26 November 2014

Letter of support - Lismore Base Hospital – Stage 3B

Elevations 3B2

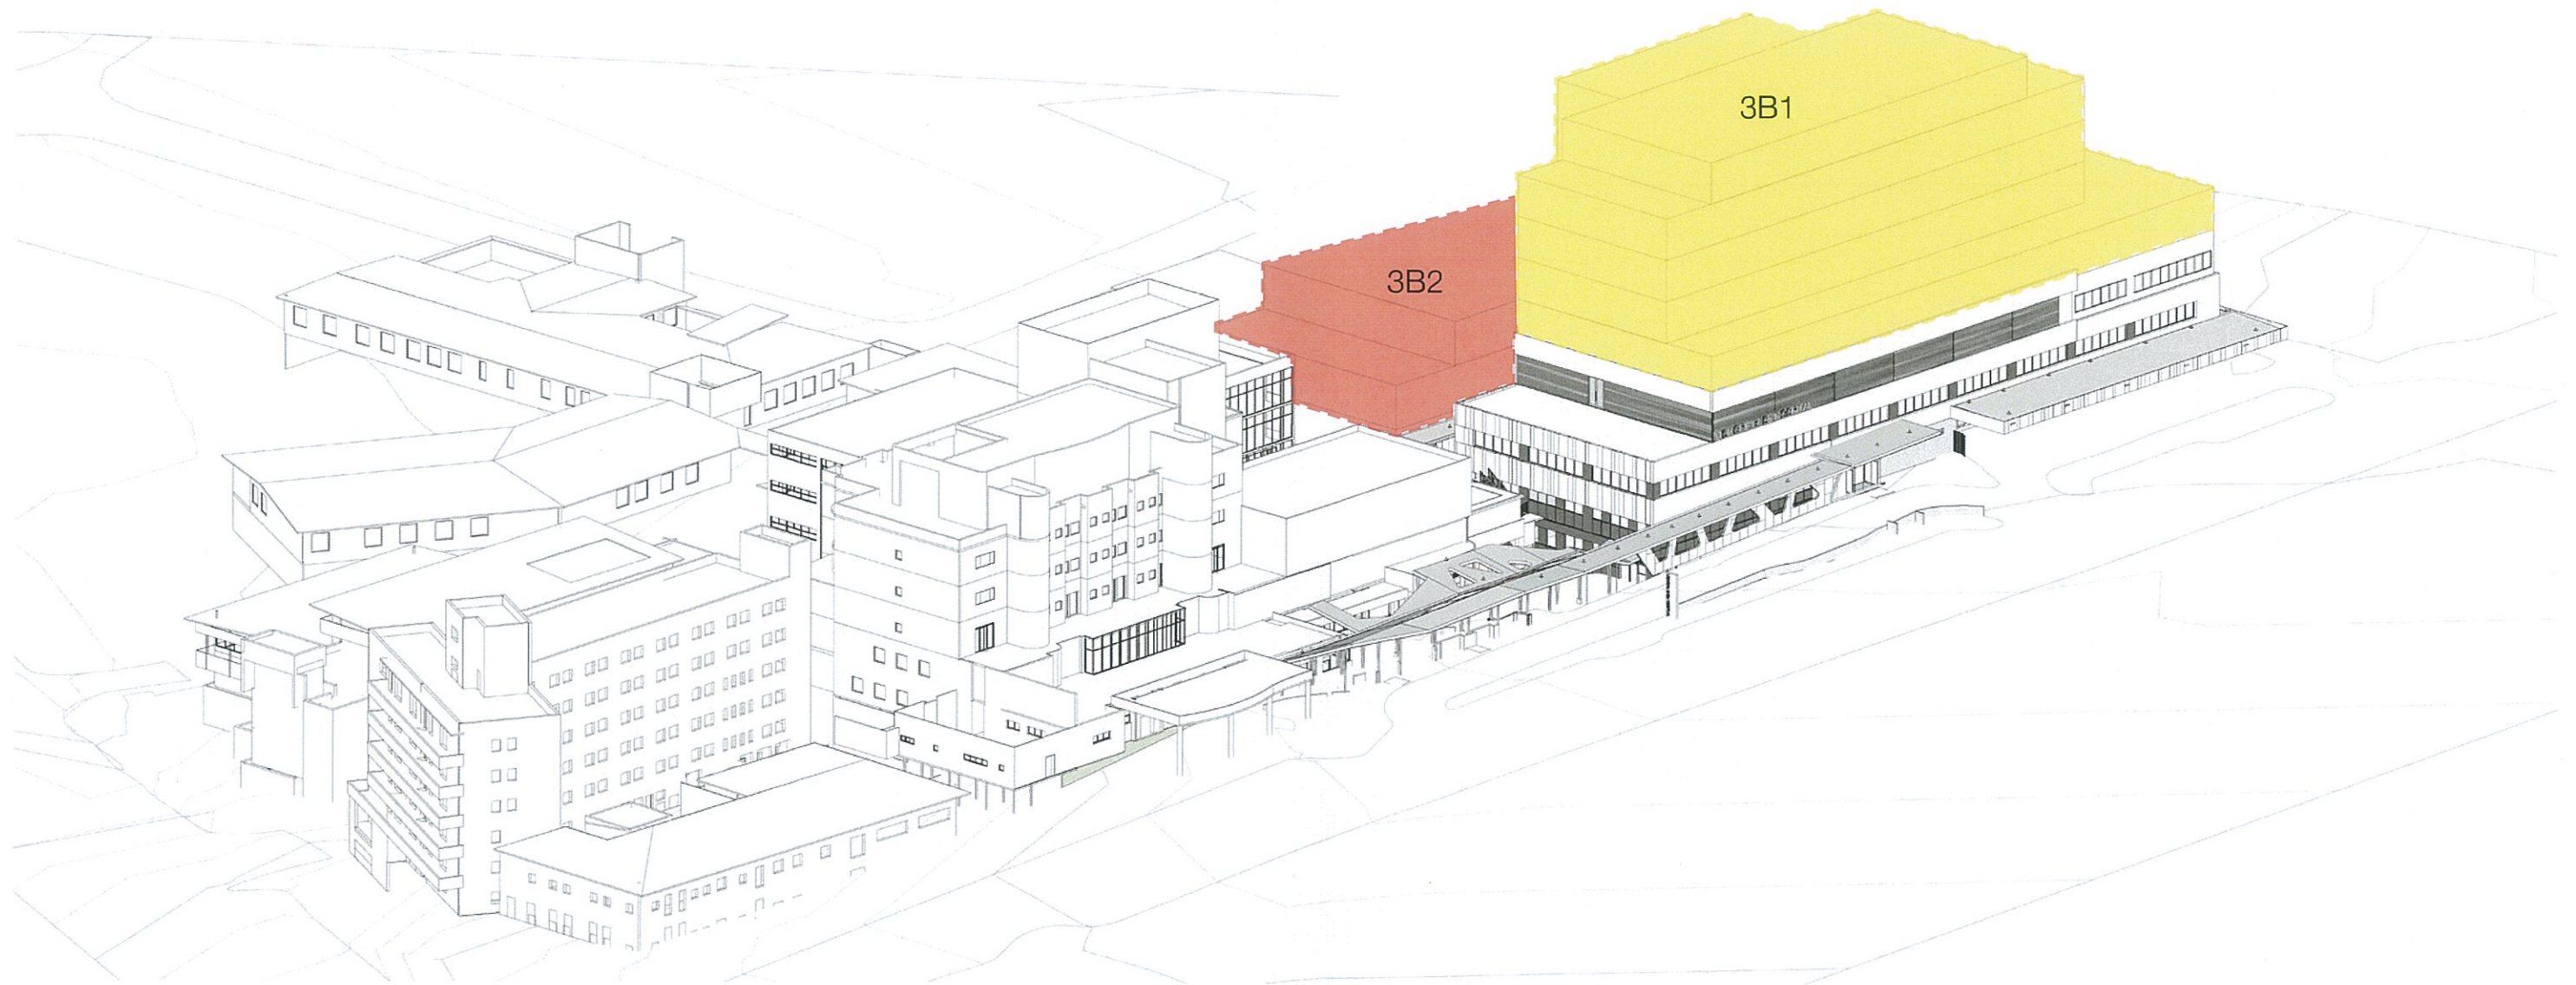
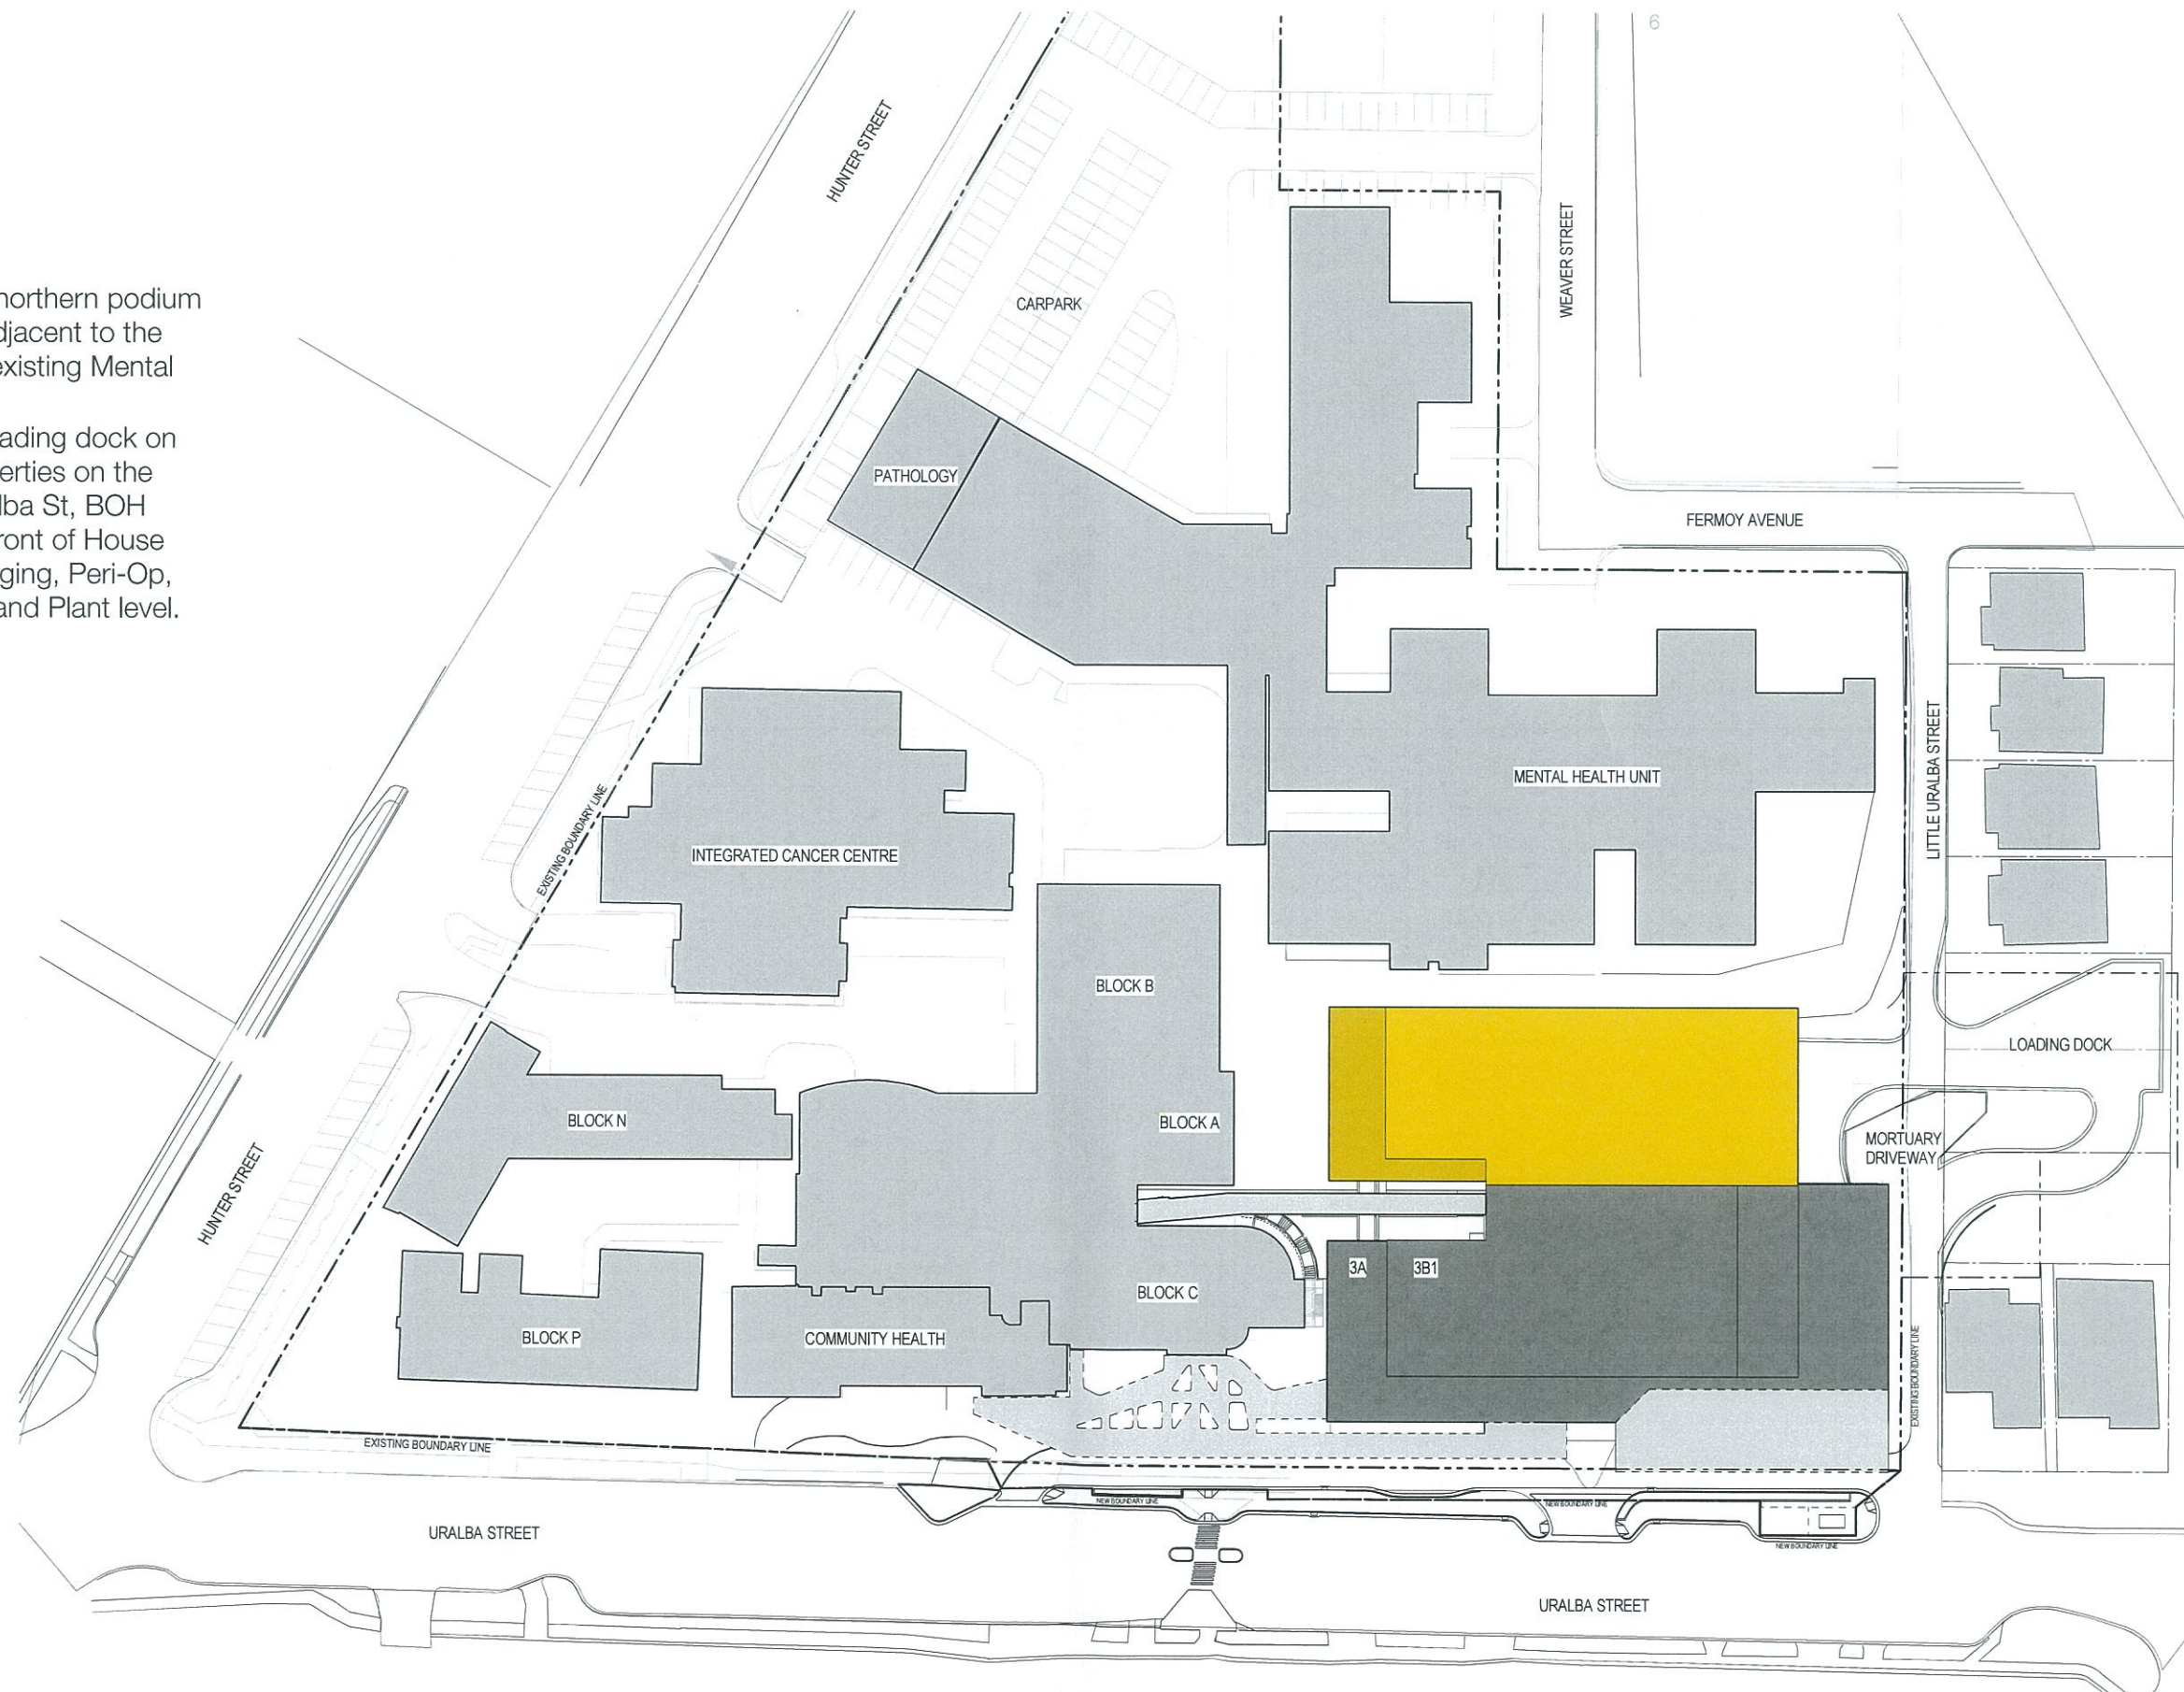
The second part of the proposed 3B stage is a five level building that has been integrated into both the natural topography and the current Stage 3A works. It is the lower level of this second part of the works that will contain the loading dock for the hospital. This area has direct street access to Little Uralba Street and is across the road from three lots which are owned by the Lismore Base Hospital.

Little Uralba Street is currently a narrow one way road servicing the Base Hospital and four other residences. For your proposed vehicular and truck manoeuvring areas to function well it will be necessary for you to integrate your open space areas on the eastern side of Little Uralba Street with your loading areas on the west. This integration will require the closing of part of Little Uralba Street. Council supports this proposal as it ensures the level of service on Uralba Street remains high, provided the remaining residents in Little Uralba Street and the public generally are provided with serviceable carriageways, pedestrian areas and vehicular turning areas.
